Application number: 2024/93198	
What is the application for?:	Erection of first floor extension to front and single storey side and rear exten
Address of the site or building:	22, Goldcrest Court, Netherton, Huddersfield, HD4 7LN
Postcode:	HD4 7LN

Proposed Site Plan
Scale 1:500

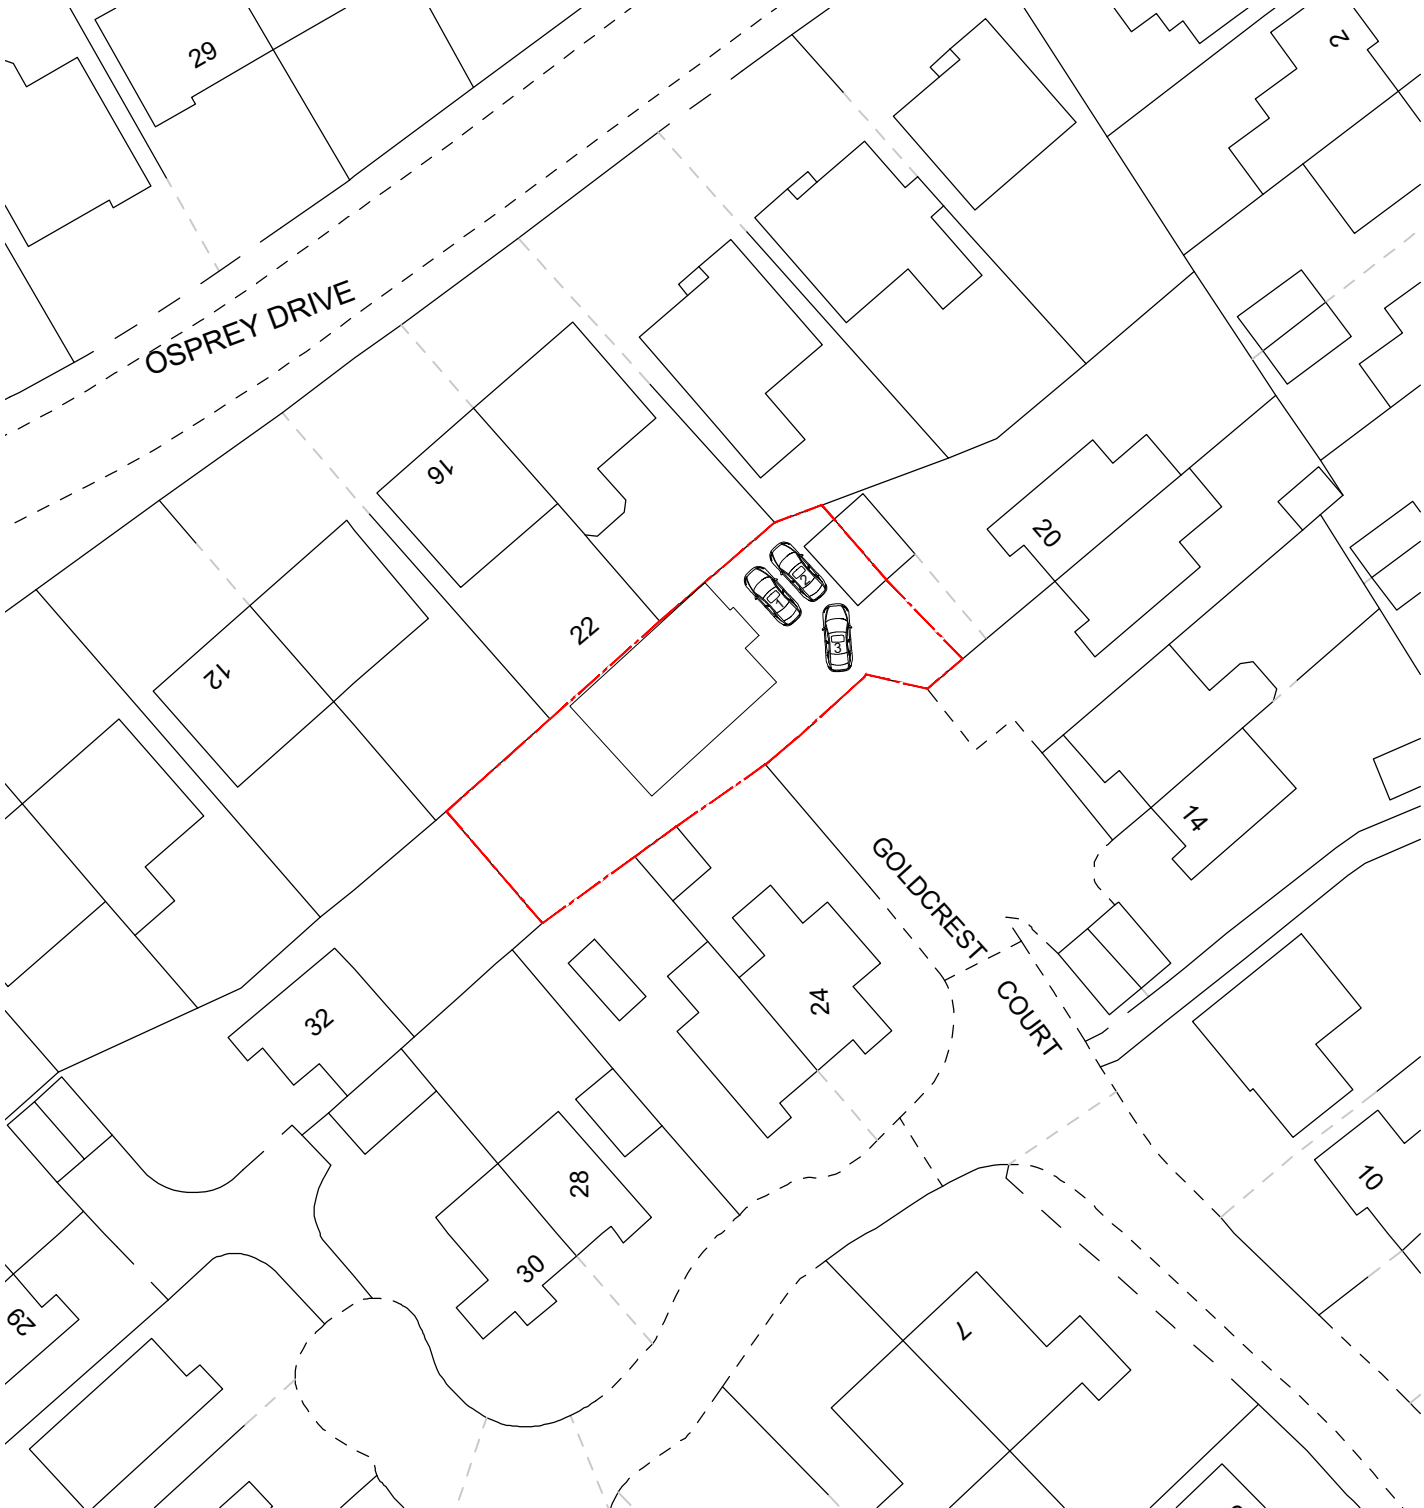
Type of comment: An objection	
Do you wish your comments to be published on the website anonymously?	Yes
<p>As in application number 2023/93348, but ammended on 2024/90951, the side extension is far too close to our boundary. This will require access to our land during building and in future when any maintainance is required to the roof or gutters. The building of the foundation is likely to interfere with our fence foundations, could encroach onto our land and would inhibit maintainance and/or replacement of our fence at some future date.</p> <p>The side extension guttering would be below the top of our fence and the front end of it would be hard up against the fence which is not a practical situation. We consider that the extension should be a minimum of 1/2 metres away from our boundary.</p>
